V2_Drainage Report - Final_COMMENTS.pdf Markup Summary

Ascent Church

Final Drainage Report

PCD File No: PPR265

# ASCENT CHURCH PROPOSED DRAINAGE MAP

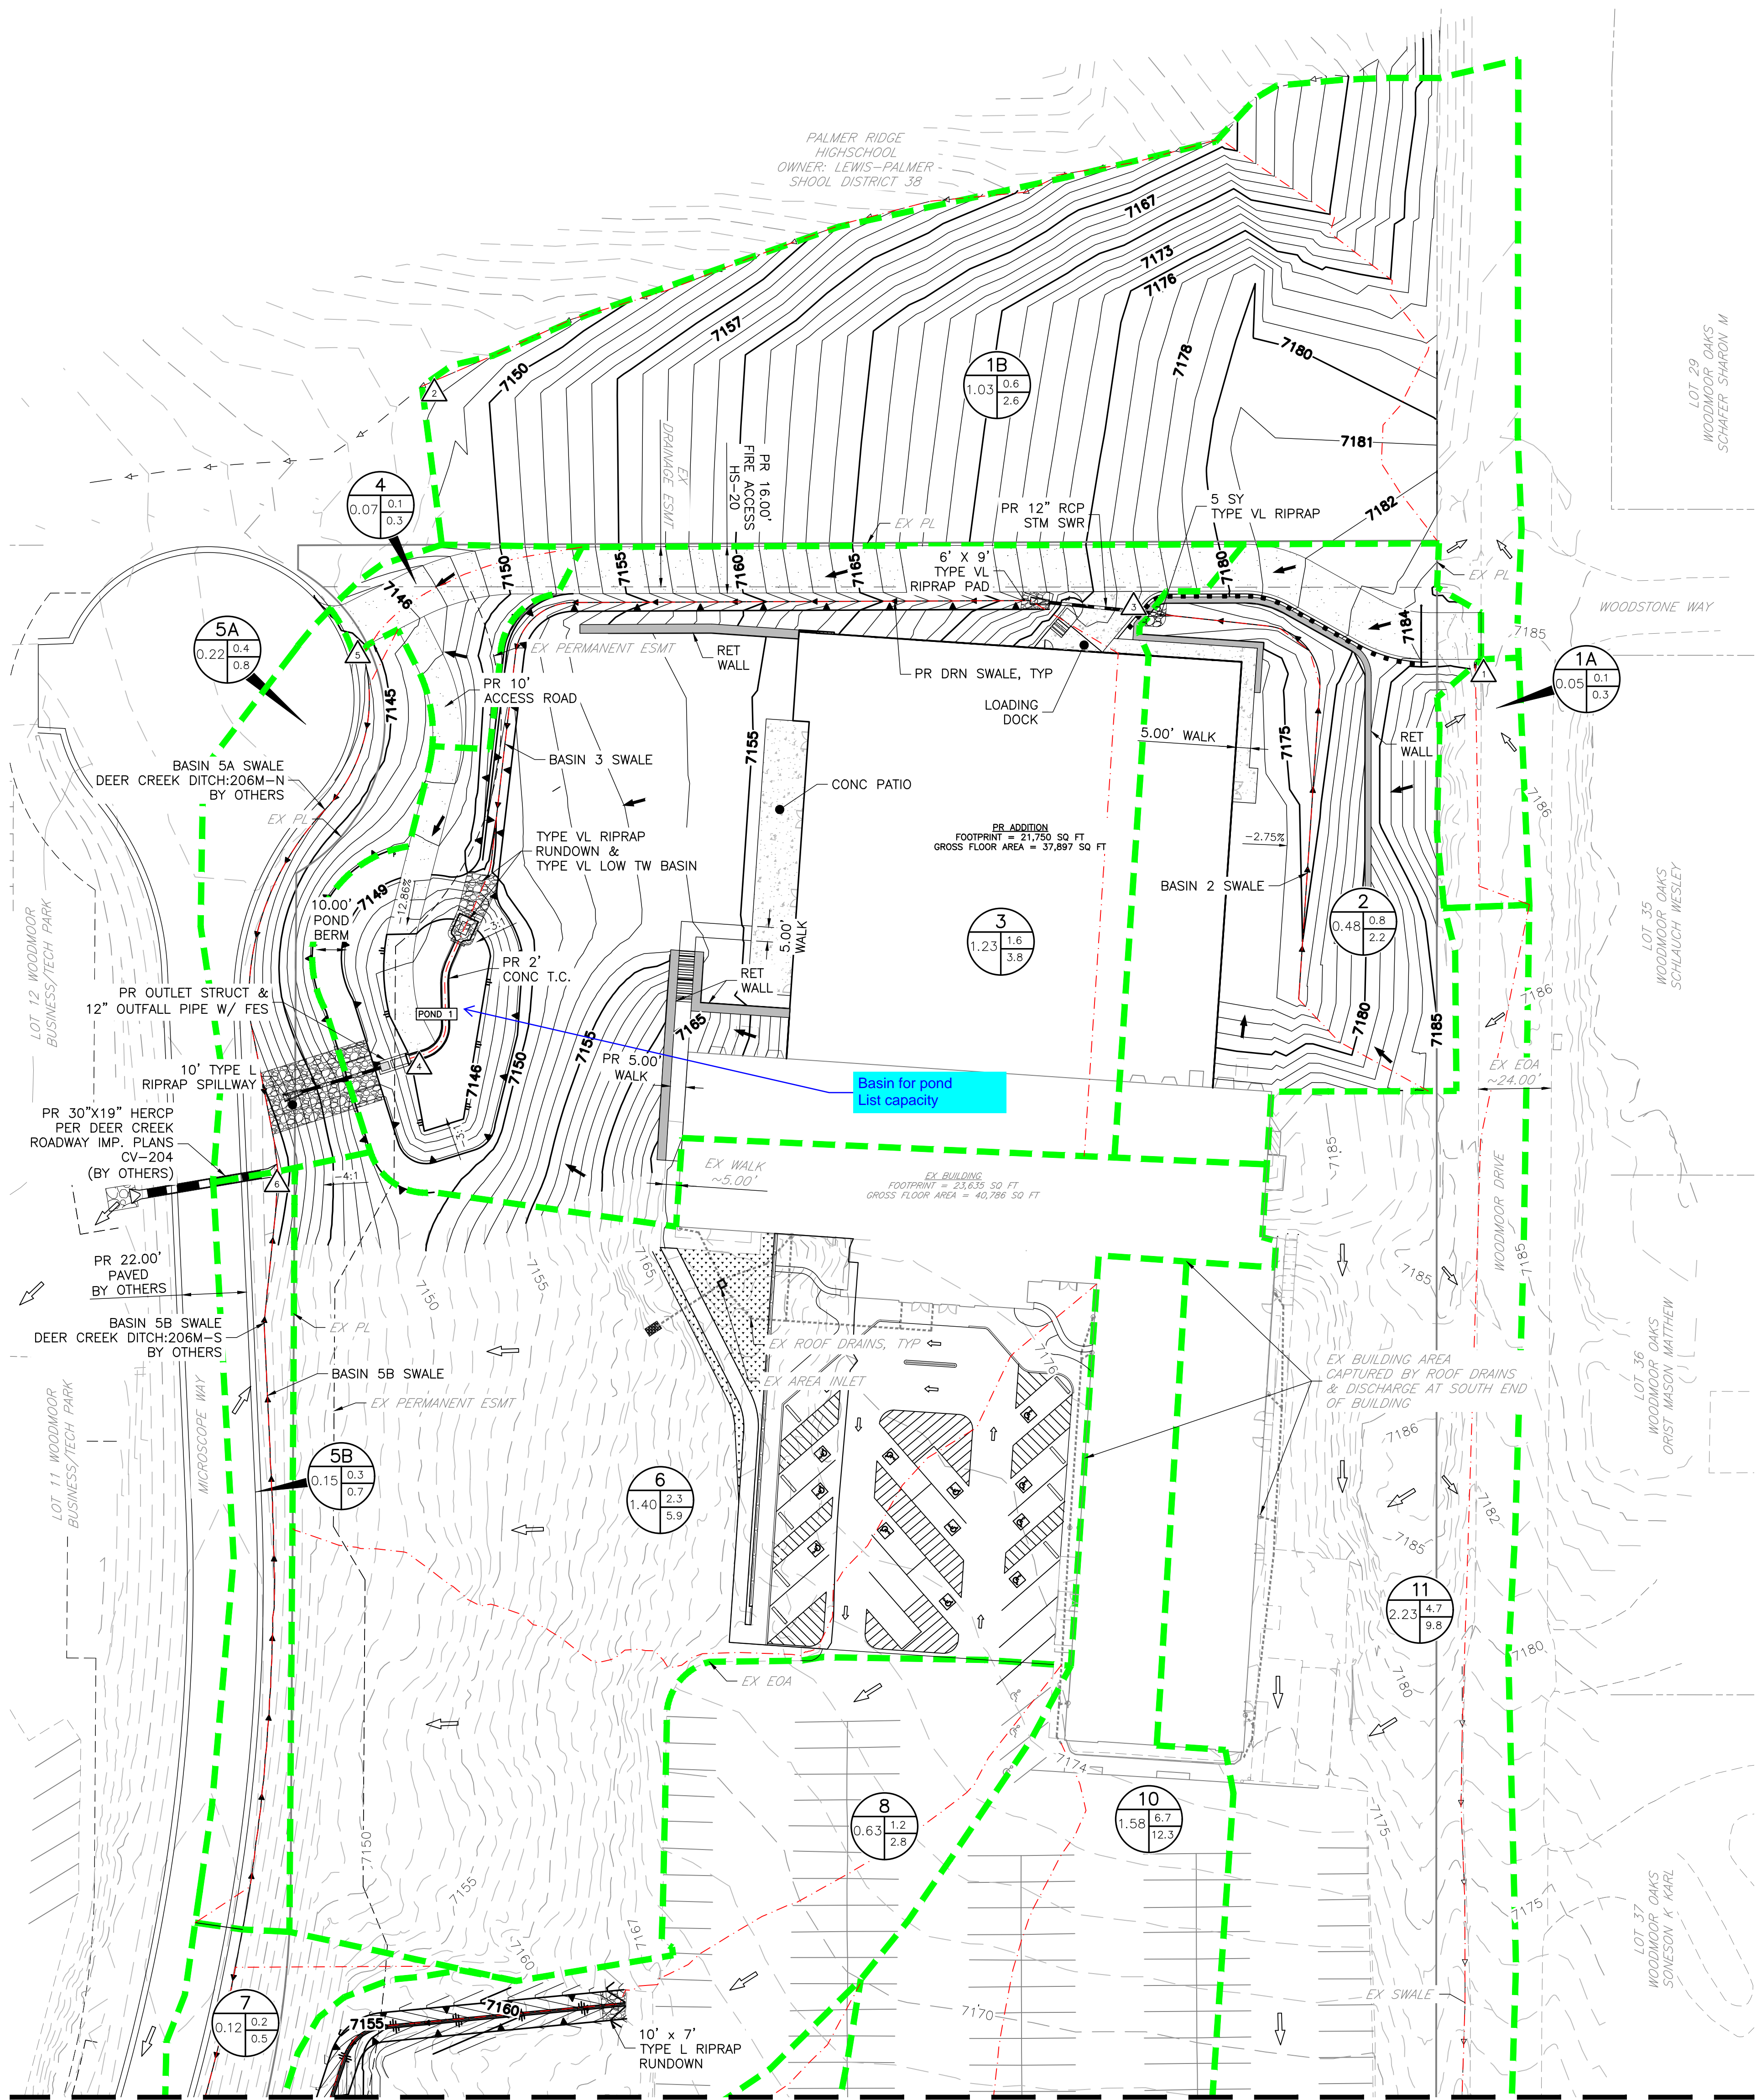
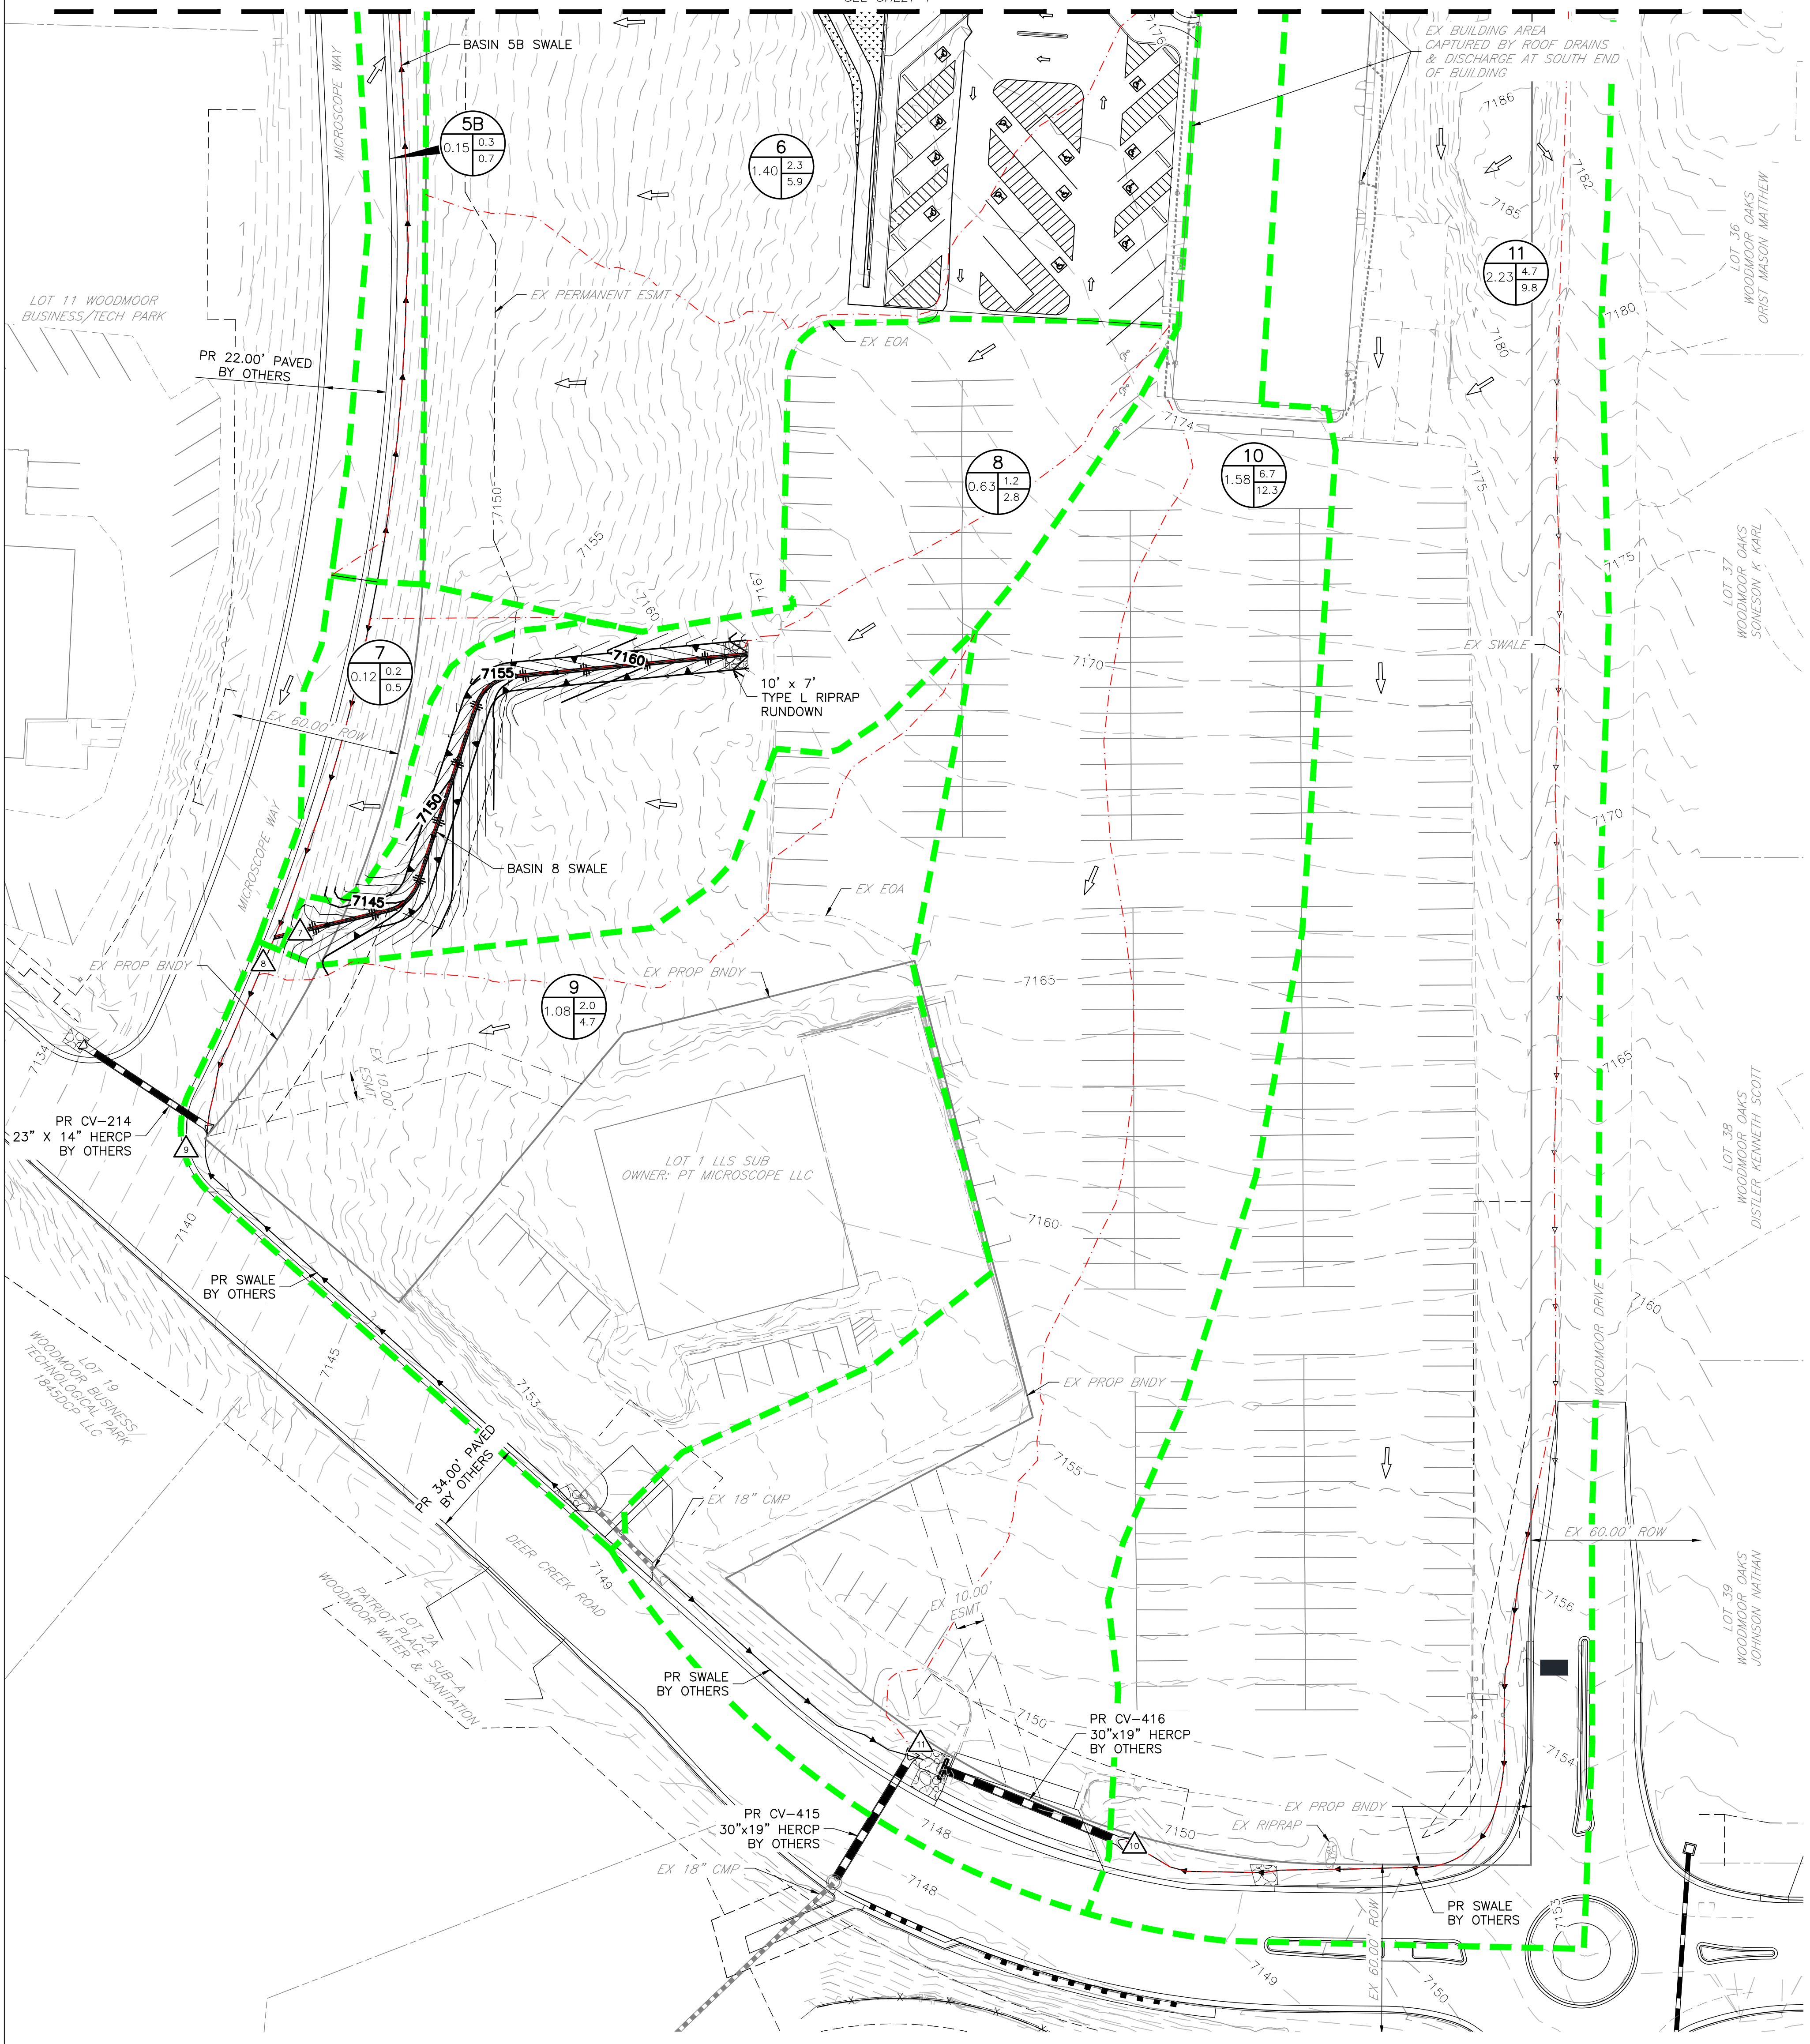
Basin for pond
List capacity

# ASCENT CHURCH PCM APPLICABILITY MAP

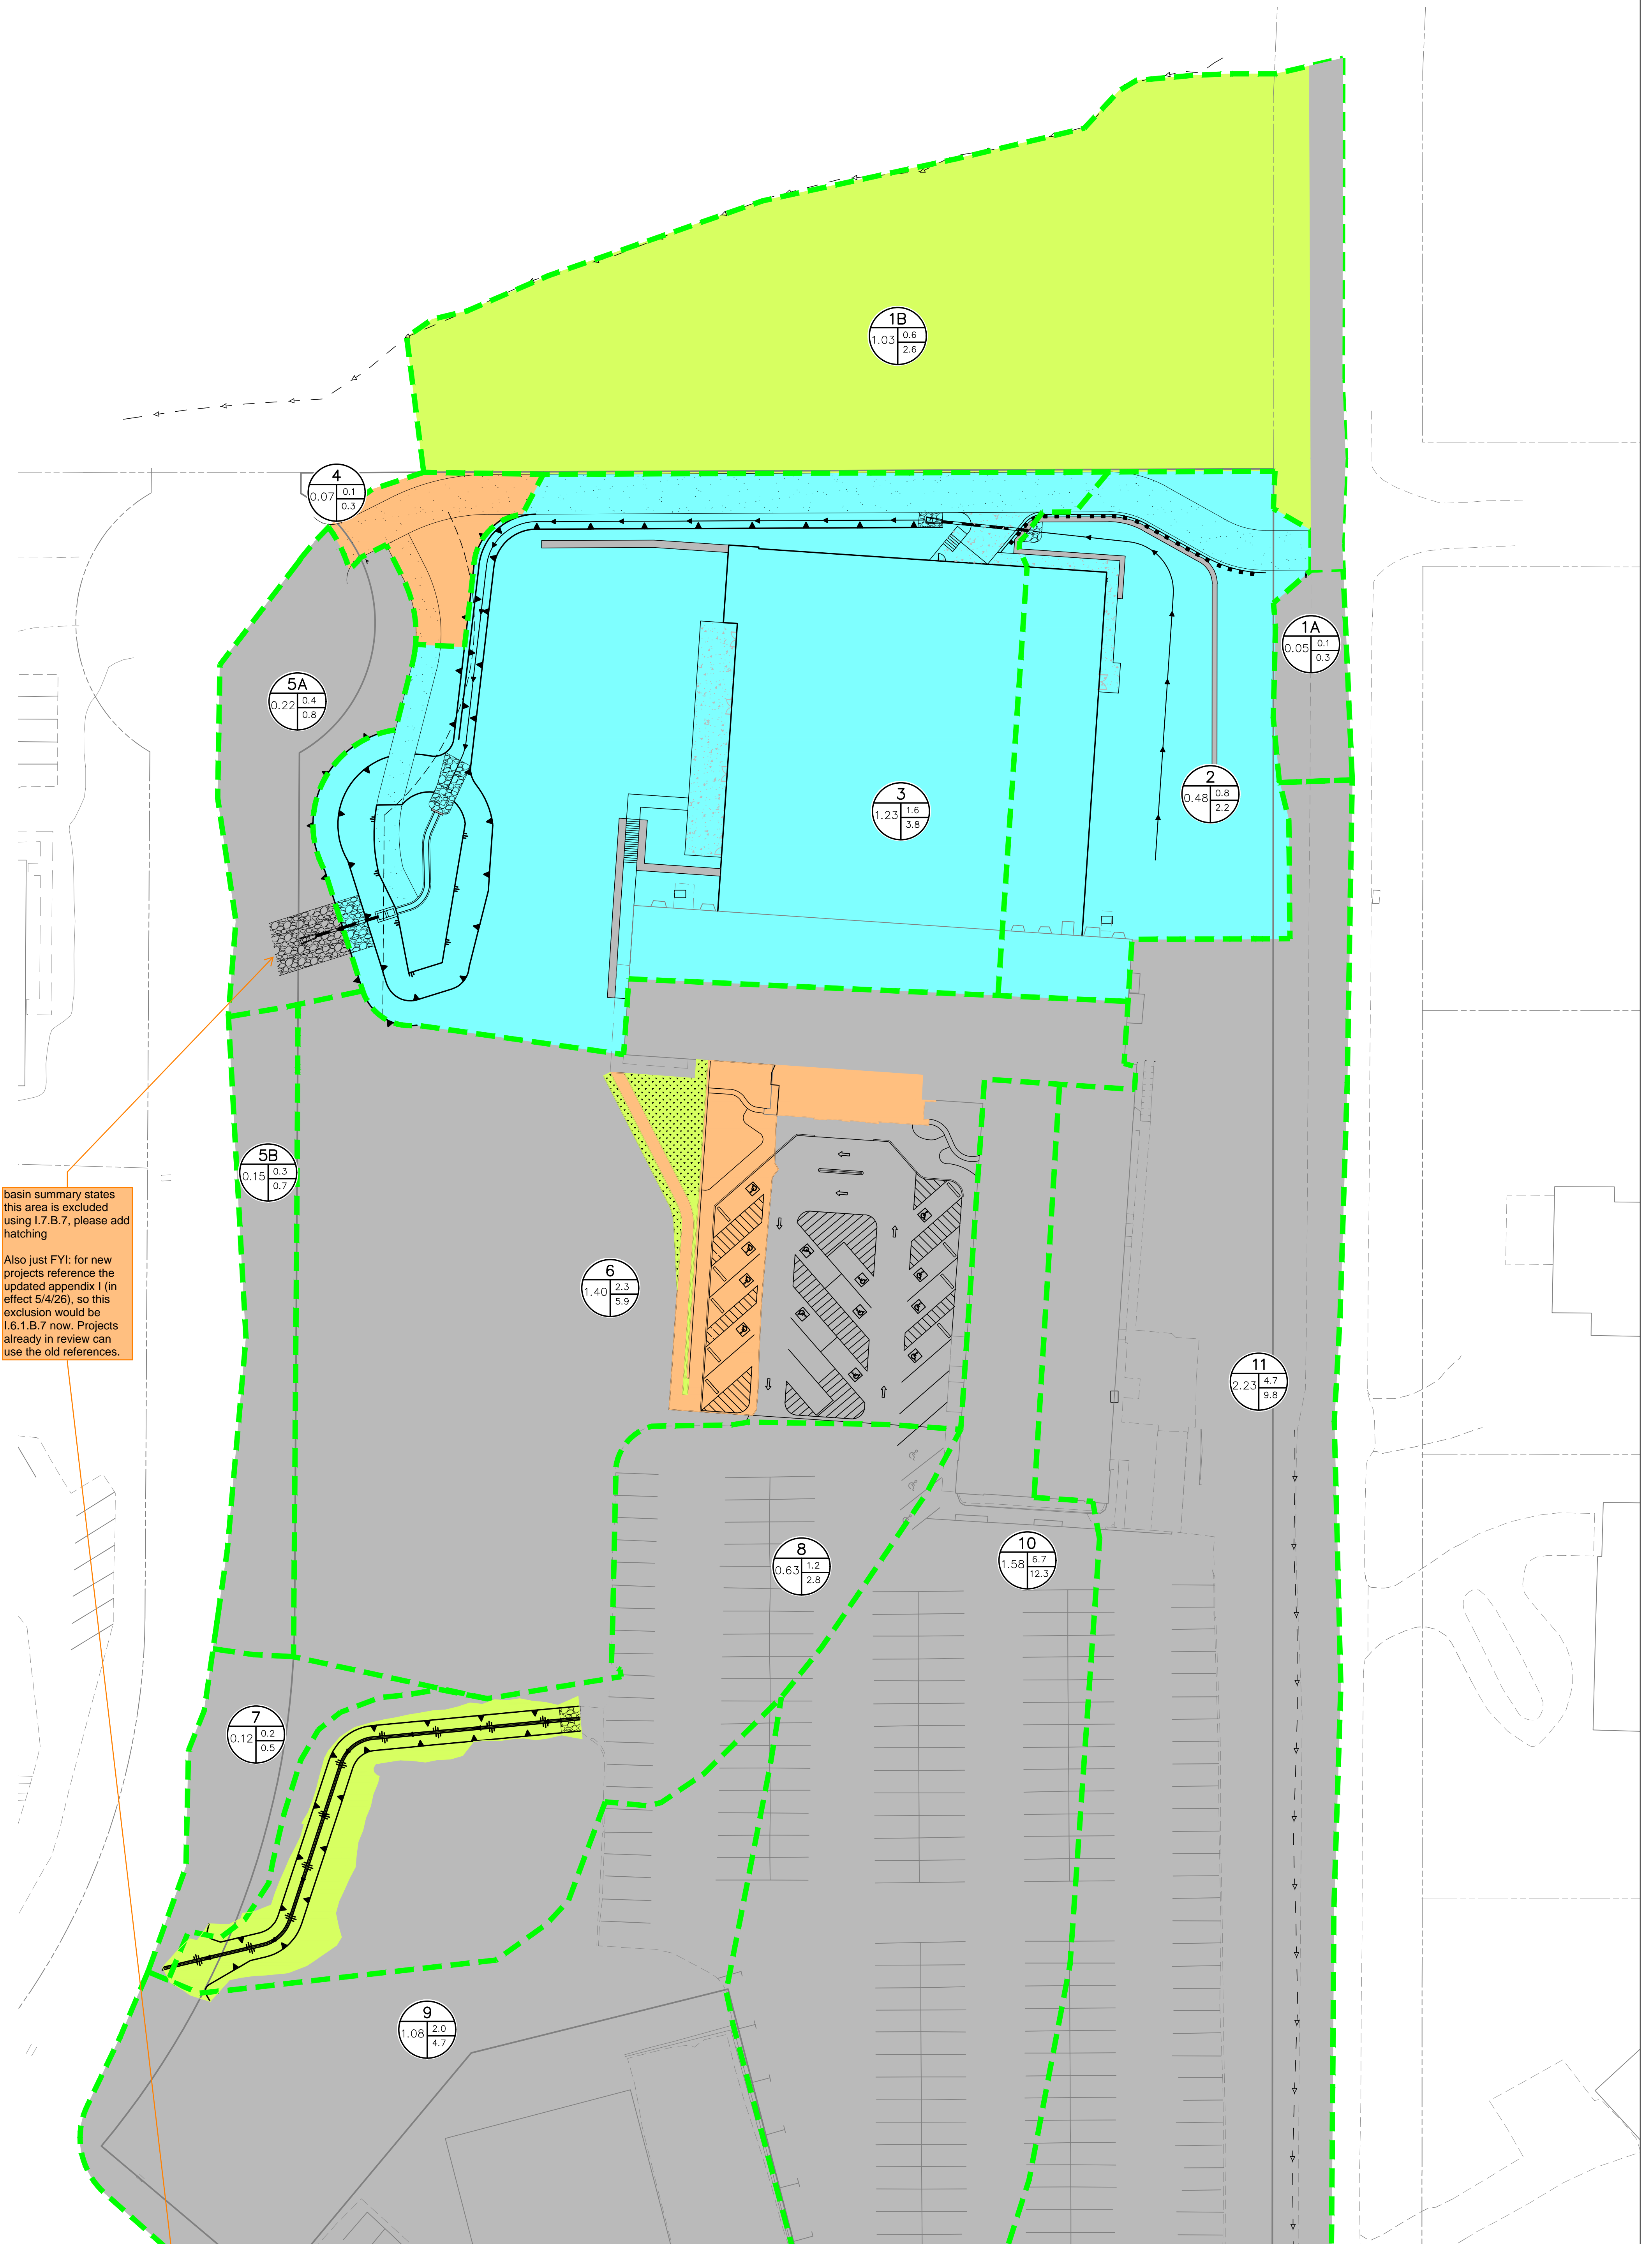
A: 1.7.B.7

1.7.1.B.7
